VOLLMER ROAD RV AND BOAT STORAGE
8815 VOLLMER ROAD
COLORADO SPRINGS, CO 80908

PROJECT NAME: VOLLMER ROAD RV AND BOAT STORAGE
PROJECT ADDRESS: 8815 VOLLMER ROAD, COLORADO SPRINGS, CO 80908
PROJECT DESCRIPTION: SITE PLAN

SHEET TITLE: **SITE DEVELOPMENT PLAN**

Site Development Plan_V1.pdf Markup Summary

VOLLMER RV STORAGE
 PRELIMINARY SITE PLAN

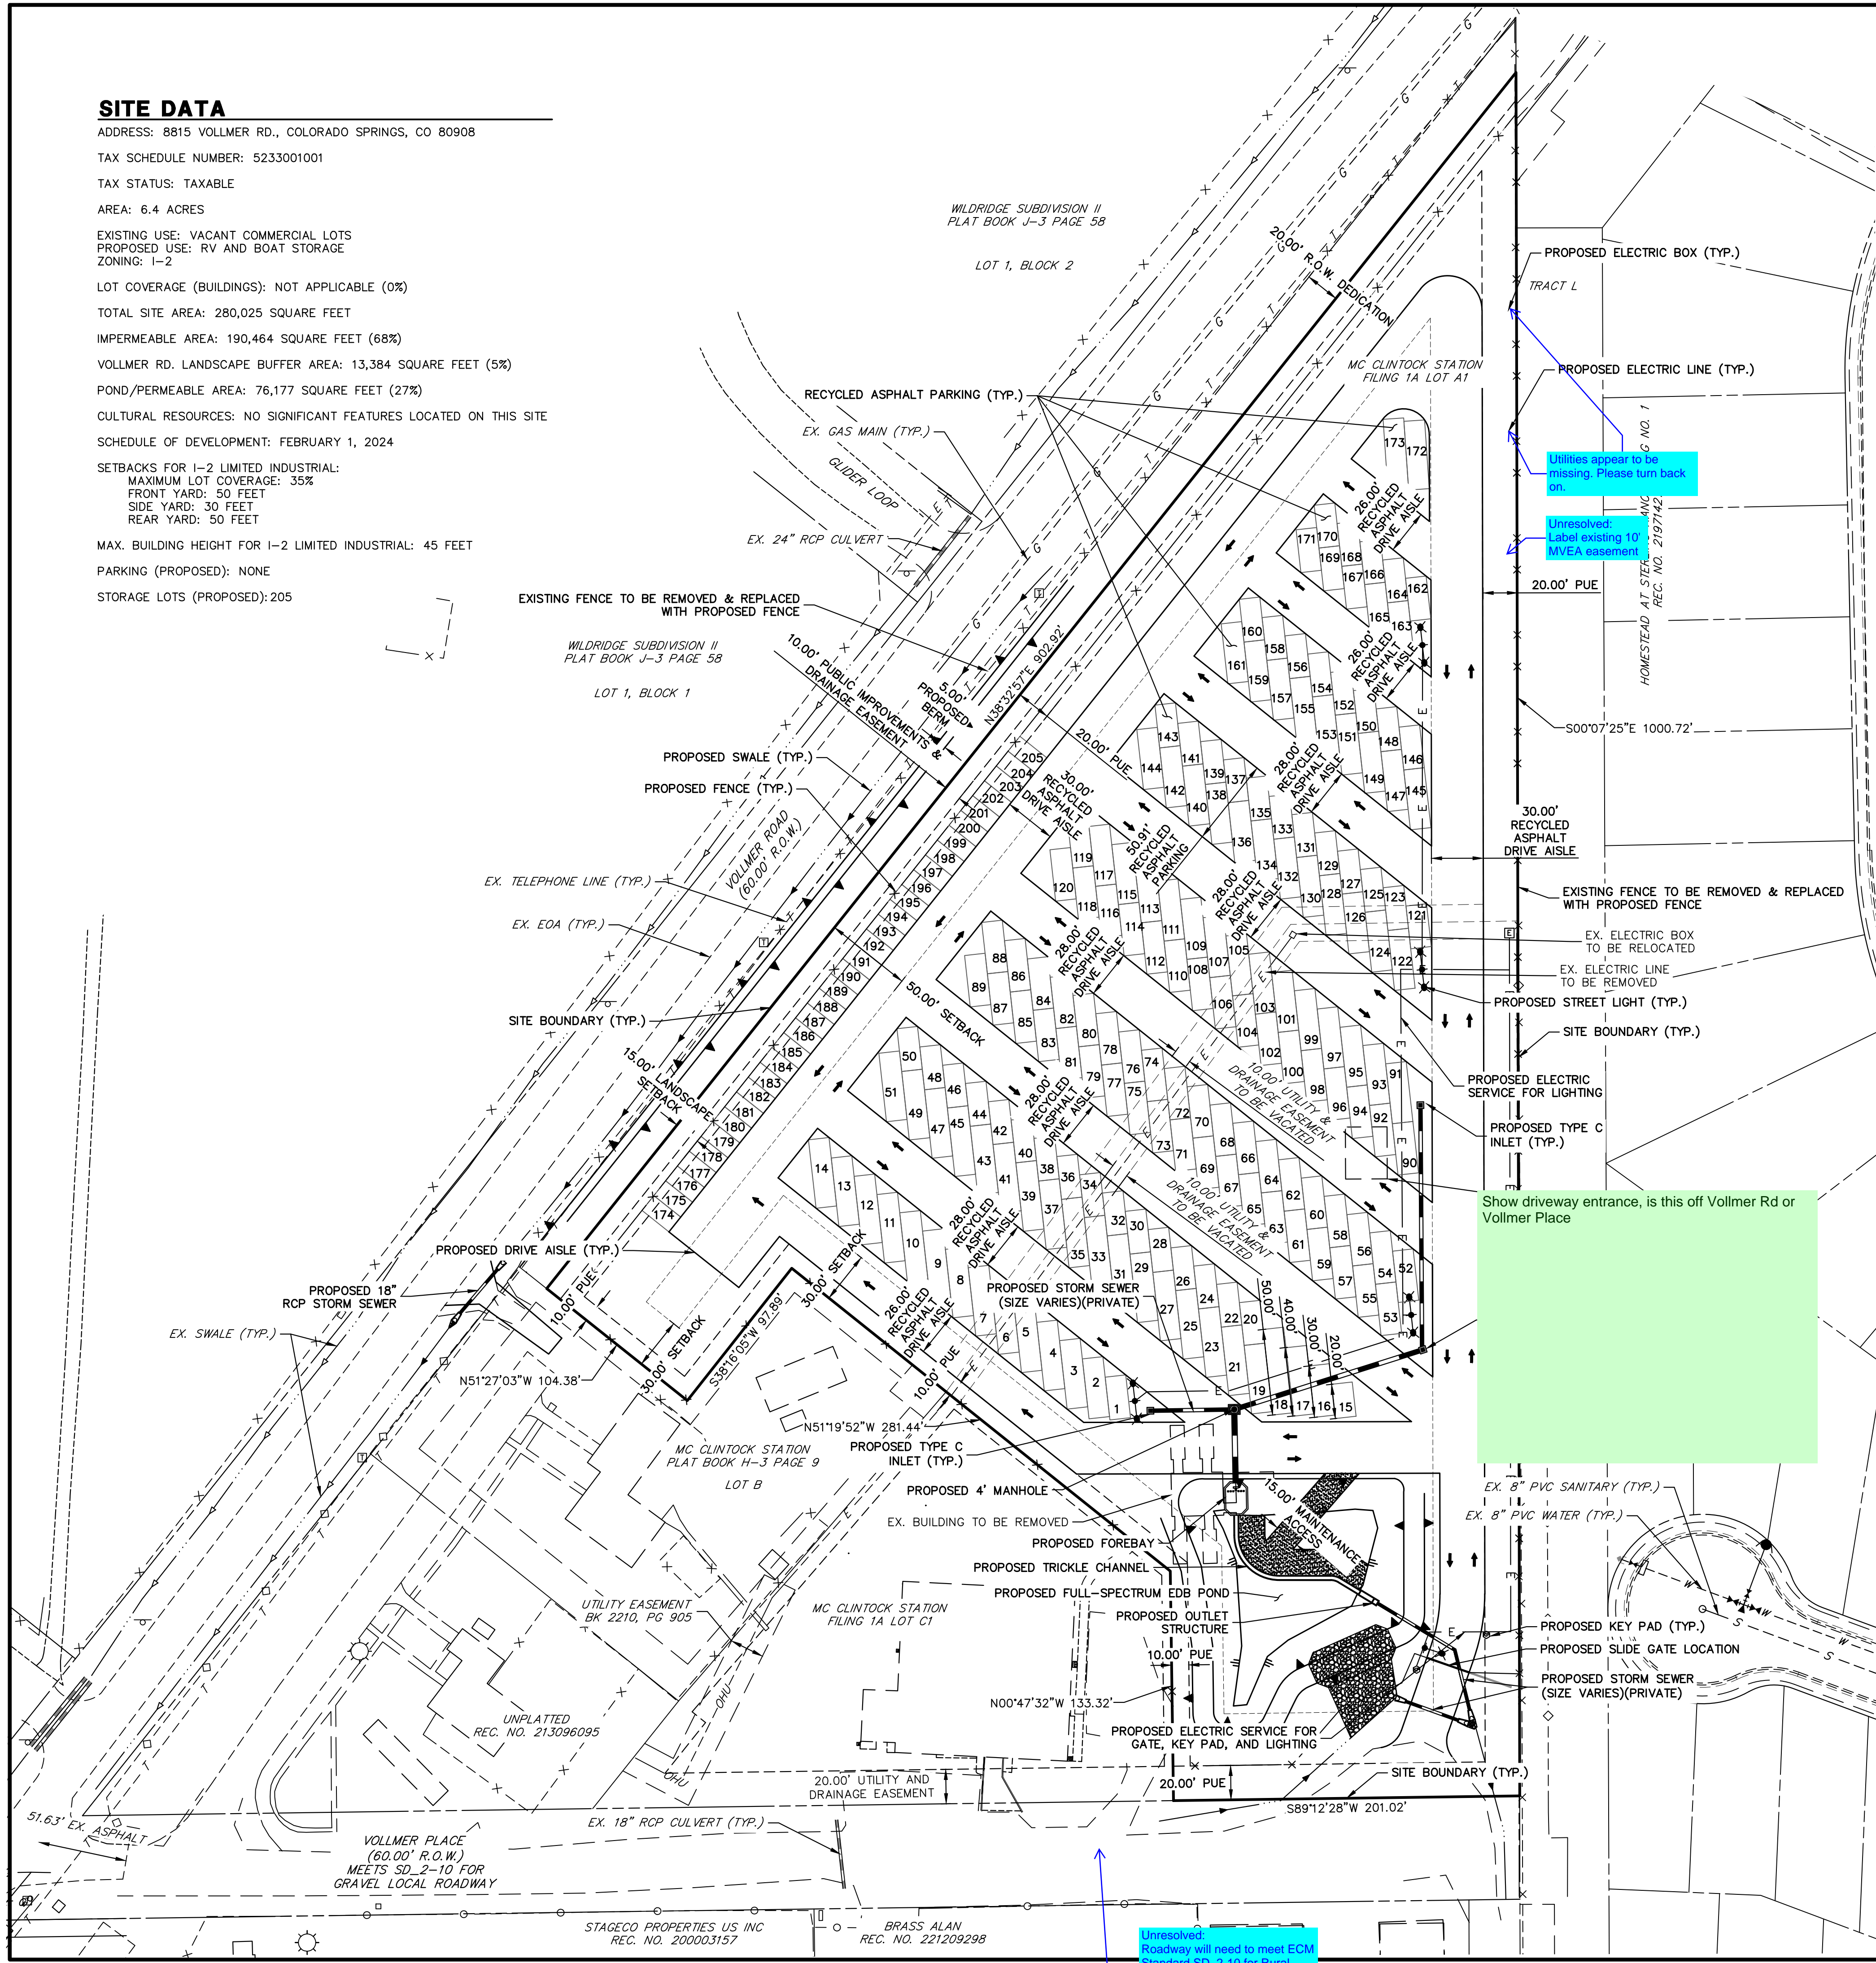
Clarify this setback per Table 4-8, Recreational Vehicle Setback Standards

Clearly identify location and dimension of the all property lines, rights-of-way, and all existing and proposed easements.

- Show on plan:
 - Location of all no-build areas, floodplain, drainageways and facilities
 - Location of all garbage receptacles with a graphical depiction of the screening mechanism
 - Location of all existing and proposed utility lines and associated infrastructure
 - Location of all sidewalks, trails, fences and walls, retaining walls, or berms
 - Location and dimensions of all existing and proposed signage on site

Add a signature block for the Planning and Community Development Director; min. 1" x 2"

Label what buffer is for

Include ROW width & roadway classification

Label boundary with lengths and bearings

Clarify this setback per Table 4-6. Recreational Vehicle Setback Standards

Minimum Area of Park. Recreational vehicle parks shall have a minimum area of 5 acres. Please contact PCD Staff regarding submitting for an Administrative Relief application or provide if previously approved.
